Site Plan Drawing_V1.pdf Markup Summary

Subject: Cloud+
Page Label: 1
Author: John Green
Date: 9/3/2020 11:49:16 AM
Status:
Color: ■
Layer:
Space:

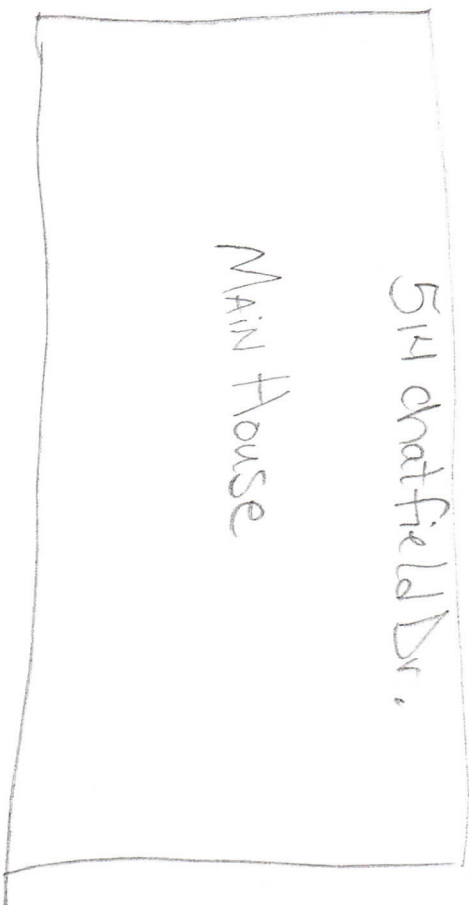
The Site Plan must be revised to include the following items:

1. Drawn to a readable scale, with the scale used in drafting noted on the document (e.g 1:20)
2. Accurately depict all property lines and the setback of each structure from each property lines. Fences are not necessarily indicative of an existing property line. The current map only shows a portion of the property and does not show the location of the existing structures in relation to the boundaries of the property.

3. Show dimension and exact location of all easements on the property. In addition, please state the type of easement as dedicated (e.g. utility, drainage, etc.).

4. All off-street vehicular parking areas must be accurately shown on the Site Plan. Garages, driveway spaces, etc. are all acceptable forms of off-street parking, but they must be drawn onto the map, at a measurable scale, to verify location and conformity with El Paso County Land Development Code standards.

5. Please include a north arrow and the street name on the revised Site Map to help give context to the proposed development.
6. Please include a map showing the surrounding zoning and land uses of the neighborhood within 500 feet of the boundary of the subject property.

7. Please include a separate document showing the height and design of the existing and proposed structures.

Once the map has been redrawn with the above listed revisions addressed, please upload a new copy of the document for review.
